From: [REDACTED]
Sent: 23 March 2017 14:06
To: Andrew Wood
Subject: Response to Planning Application Y/5/17/OUT - 51 dwellings at Cinders Nursery & Land R/O Cinders Lane

Y/5/17/OUT Cinders Nursery & Land R/O Cinders Lane Yapton

Outline application for 51 no. dwellings with all matters reserved except for access.

CONCEPTUAL LAYOUT

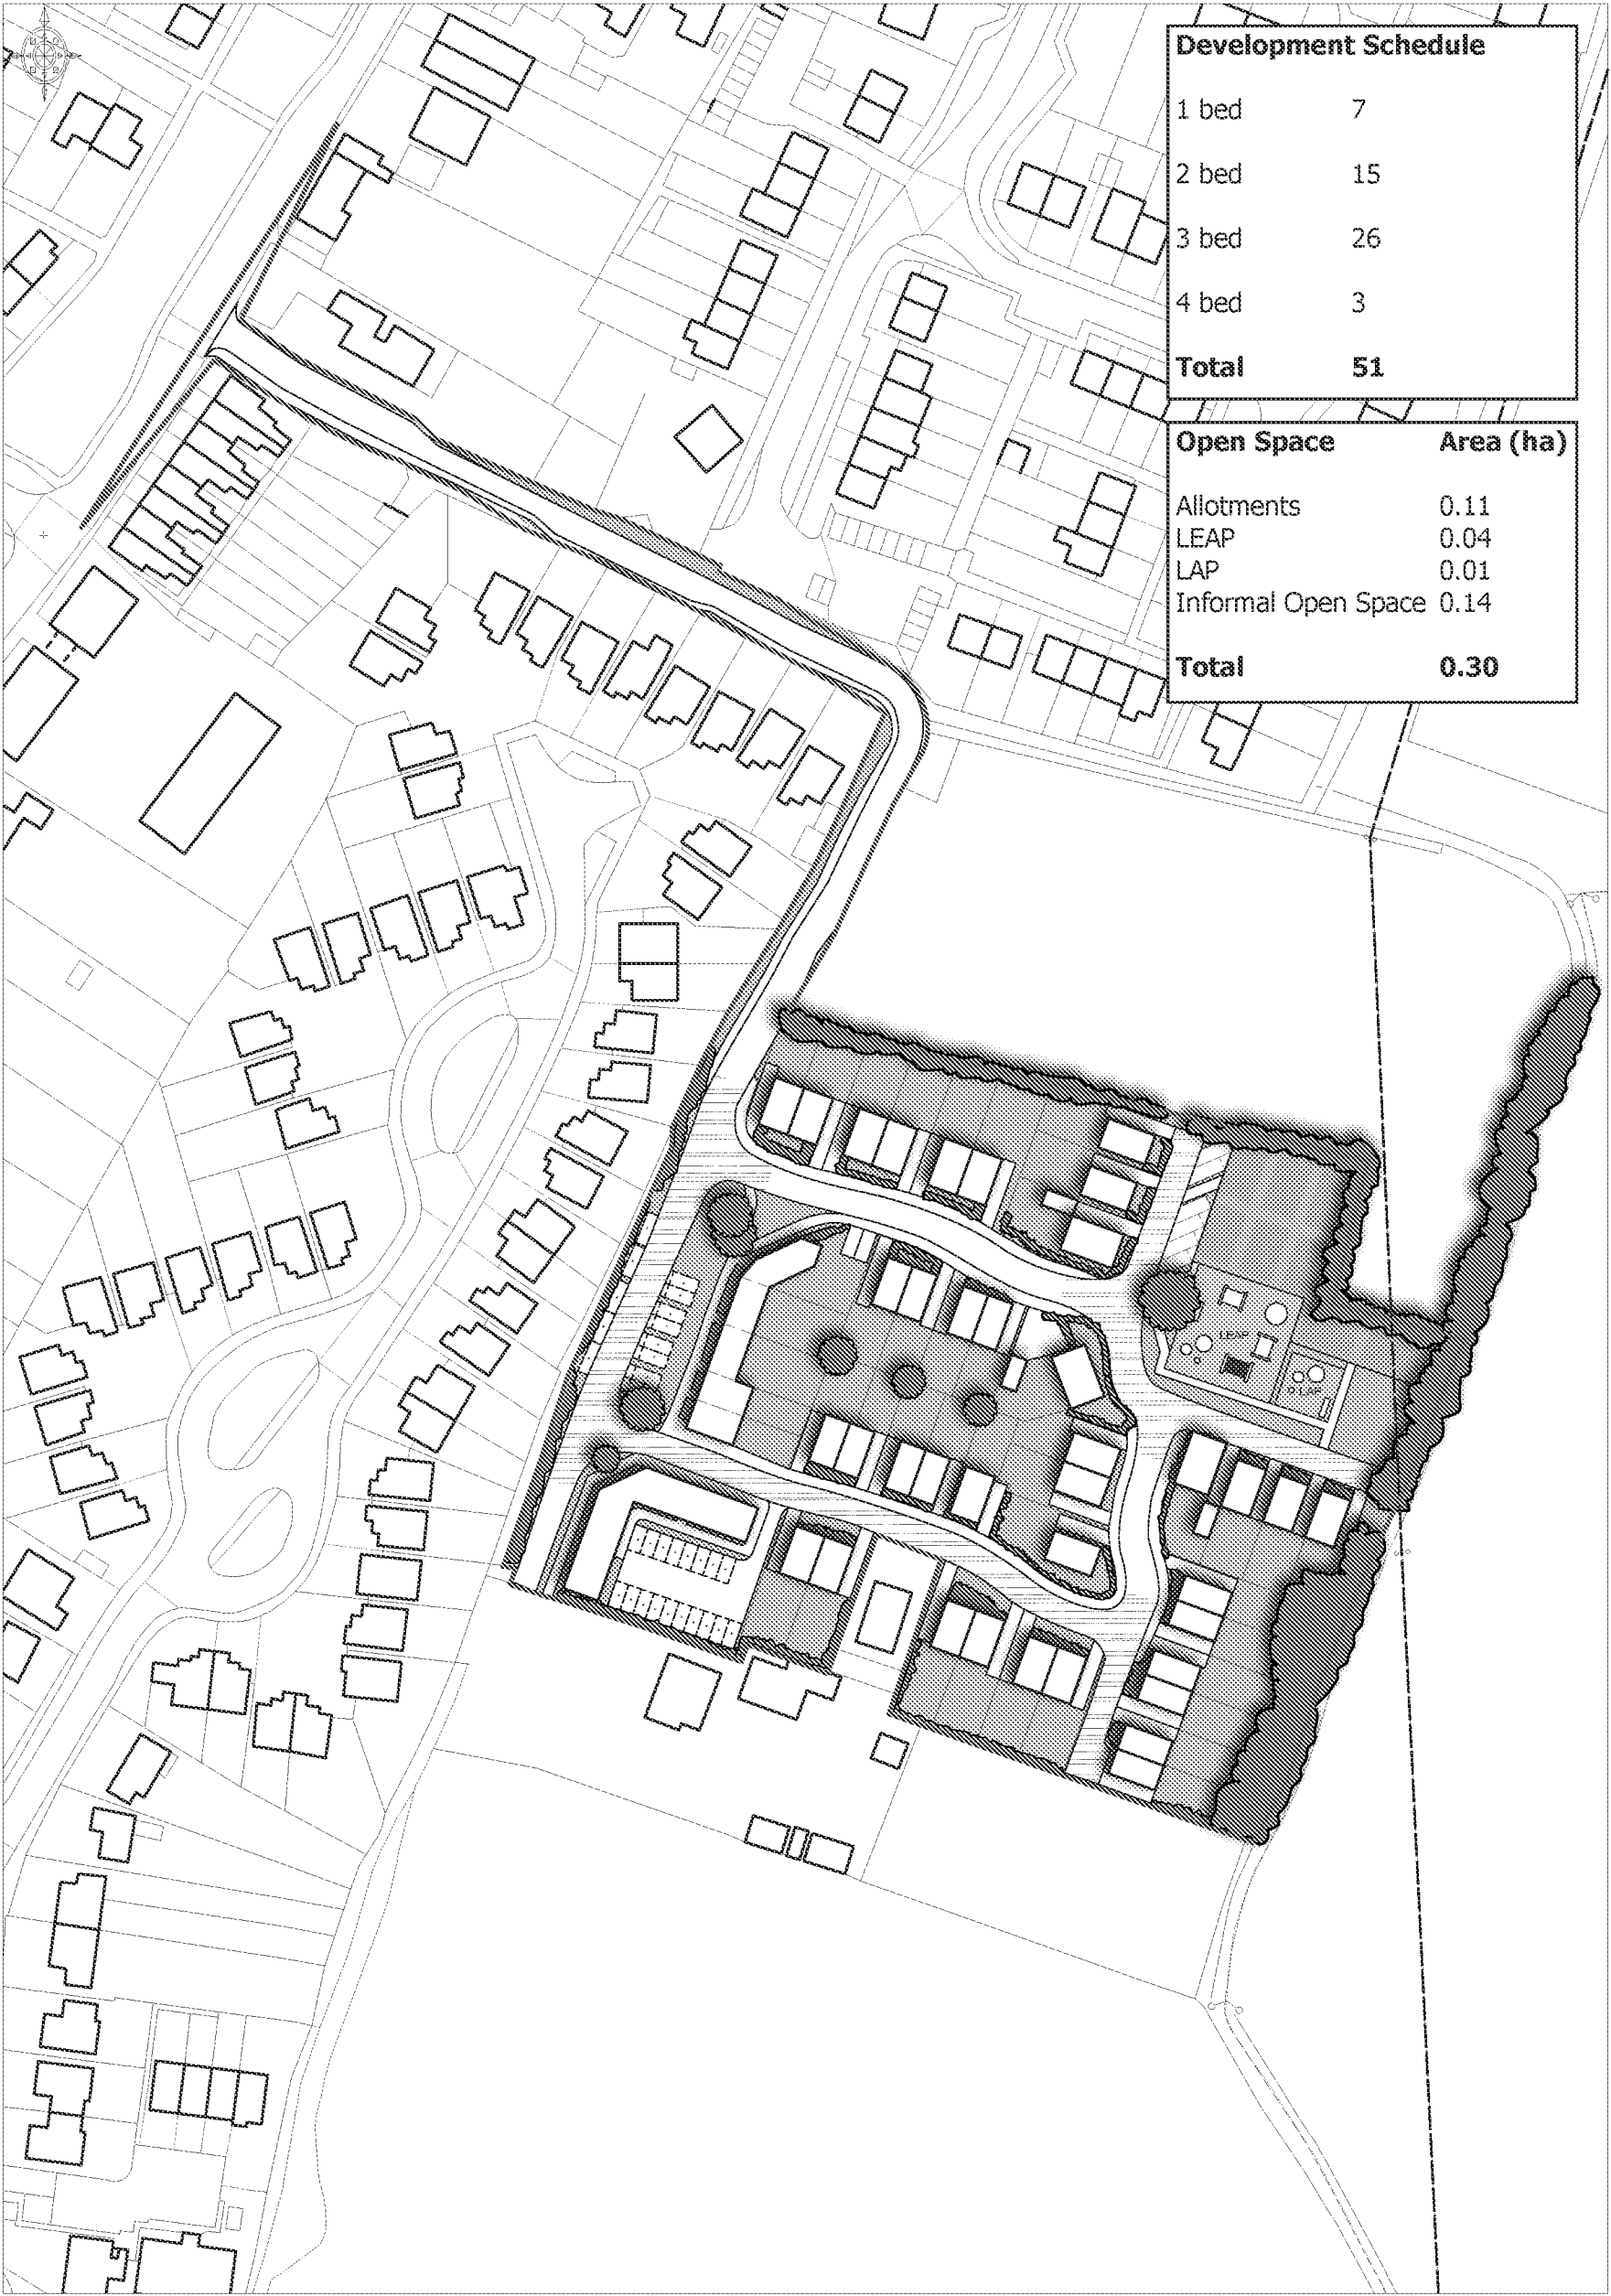
The Parish note that pedestrian links within the site are compromised with pedestrians being encouraged to cross Cinders Lane on a blind bend. We would seek better pedestrian links/walkways within the scheme linking to the existing footpaths to the north of the site, enabling easy access to the allotments and countryside without the need to cross Cinders Lane.

The proposal's outlined open space is not fully dedicated as open space but has a dual use being used in part as car parking. The Parish would seek fully dedicated open space and improved landscaping to reflect the rural nature of the site and its backdrop.

SURGERY ACCESS VISIBILITY SPLAY (SCALE 1:200)

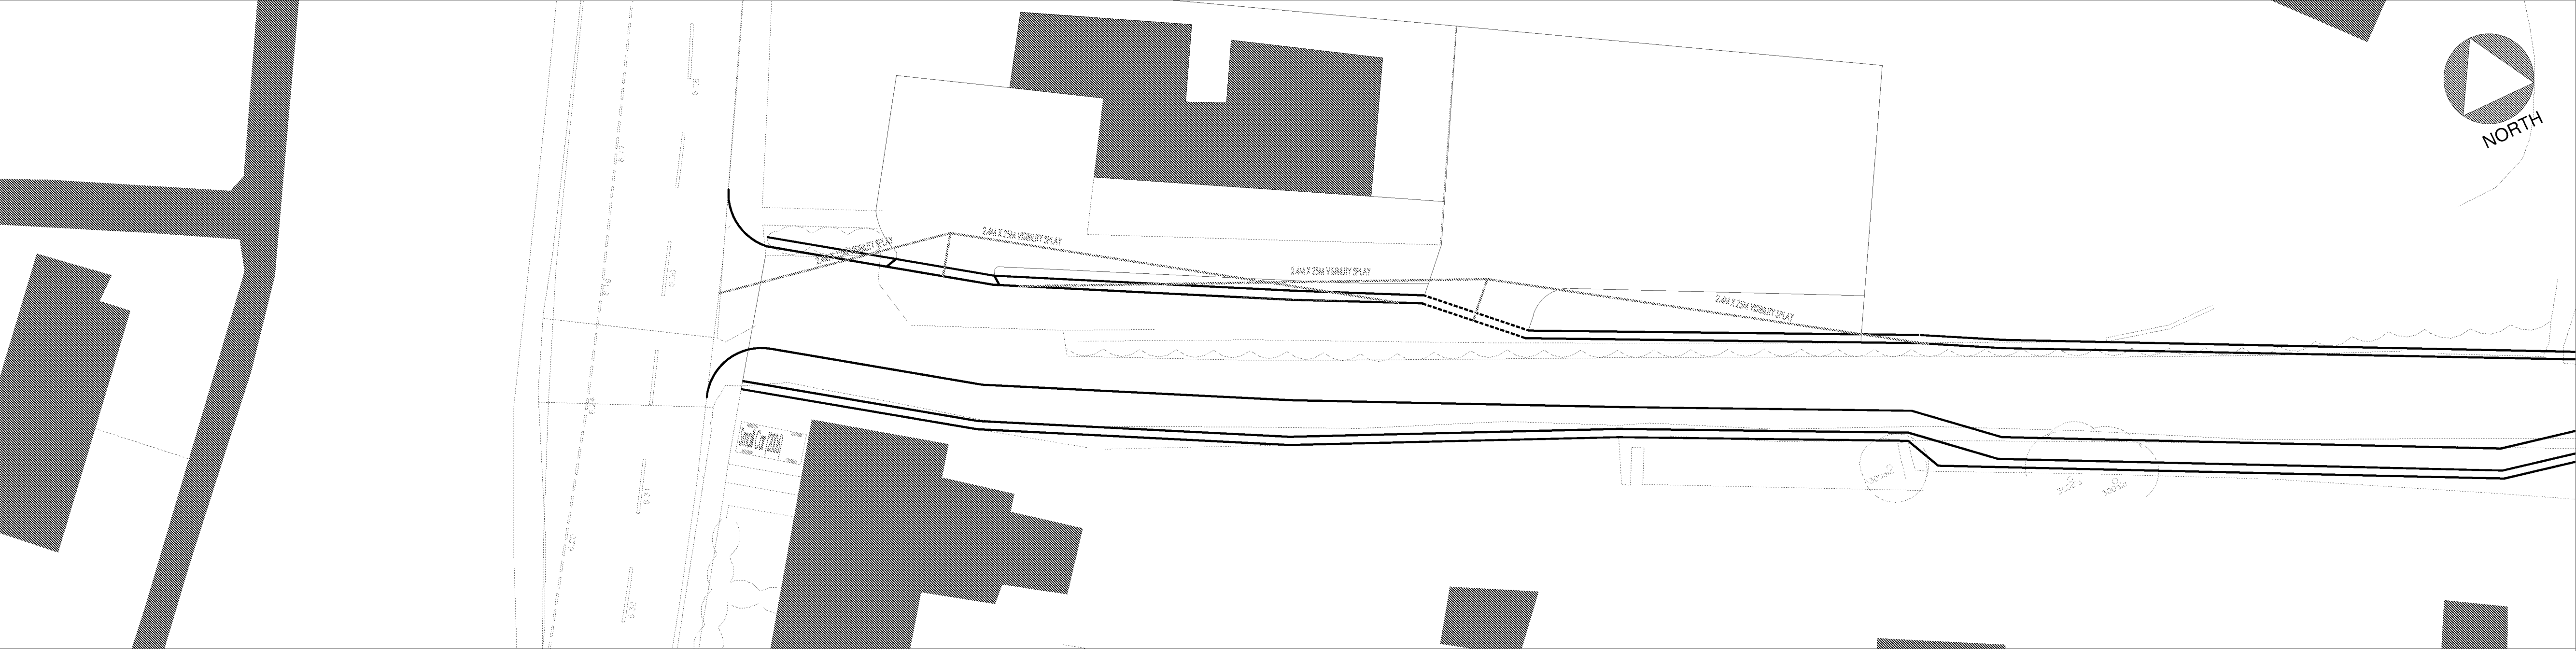
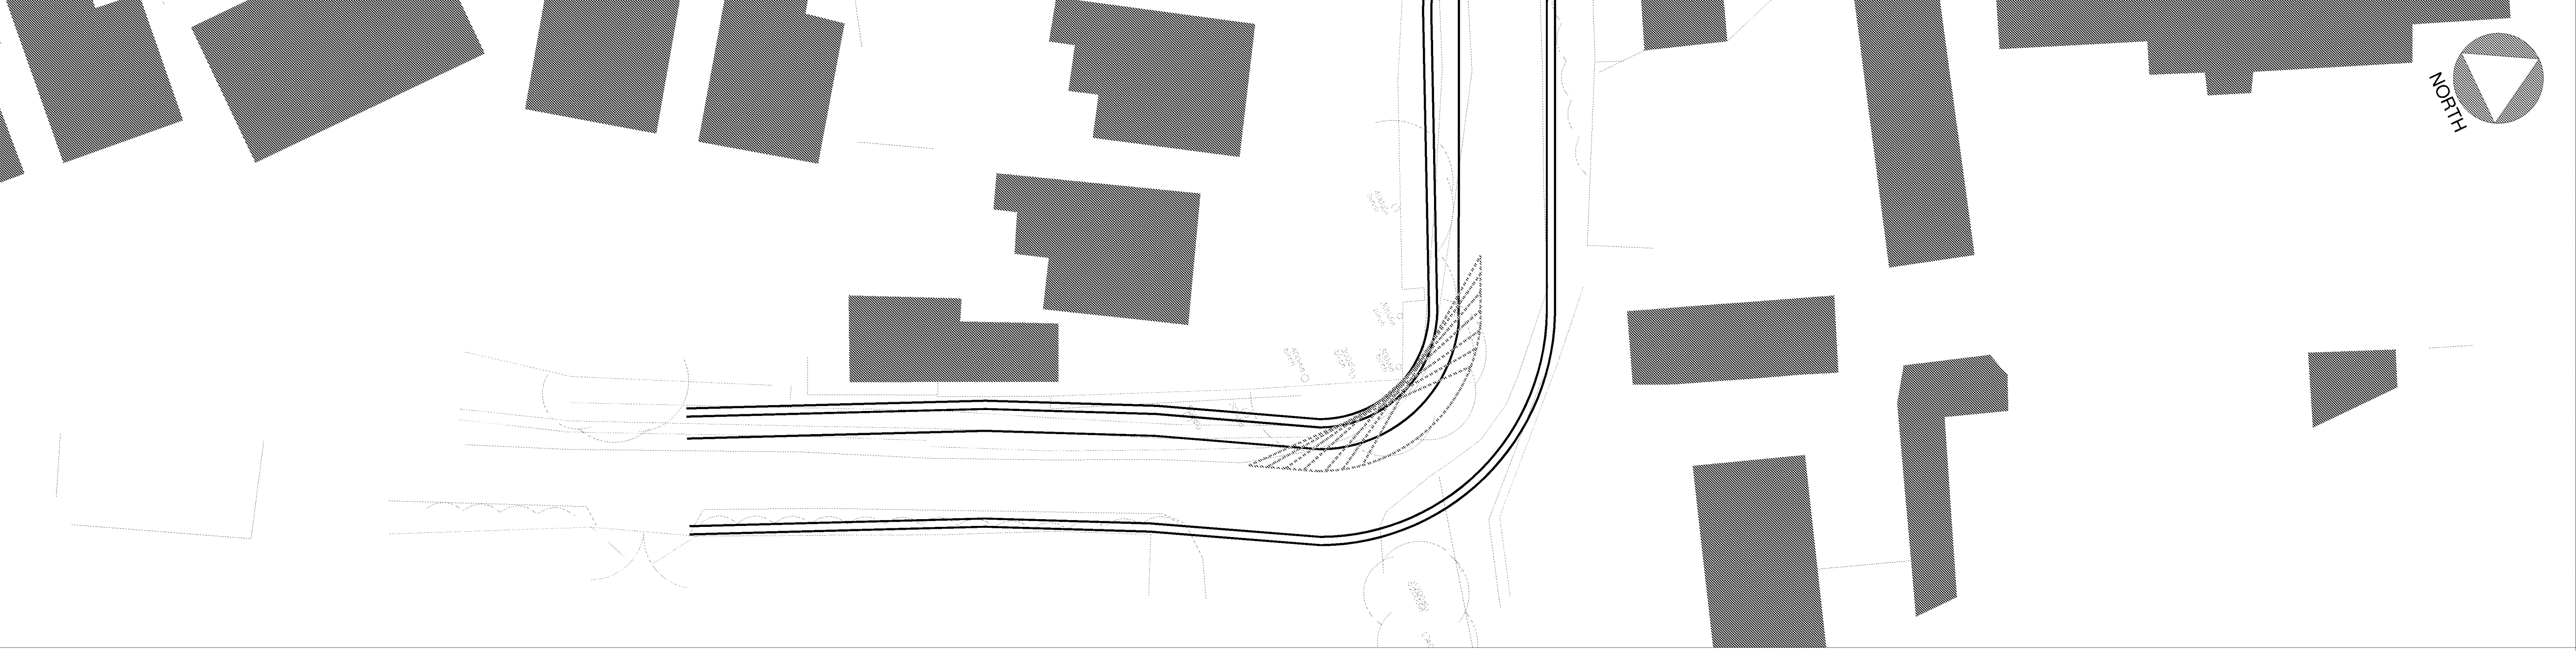
The site is accessed via a proposed improved junction with Cinders Lane and Bilsham Road. However, this section of Bilsham Road is both a busy section of road and subject to persistent congestion due to resident street parking and customers parking outside Bilsham Stores. Congestion and conflict is further compounded at this junction by traffic movements to and from Meadowcroft Surgery and the allotments. There is a need to ensure that pedestrian access to Bilsham stores and the surgery remain safe and a more robust solution put forward to ensure a safe junction for cars and pedestrians. The Parish Council would ask that this junction and its proposed site-lines be re-examined along with the surgery parking arrangement.

The Parish would suggest that the surgery has only one access point or a restriction placed on the front car park ensuring that it is used purely for staff lessening the frequency of use of this second access point.
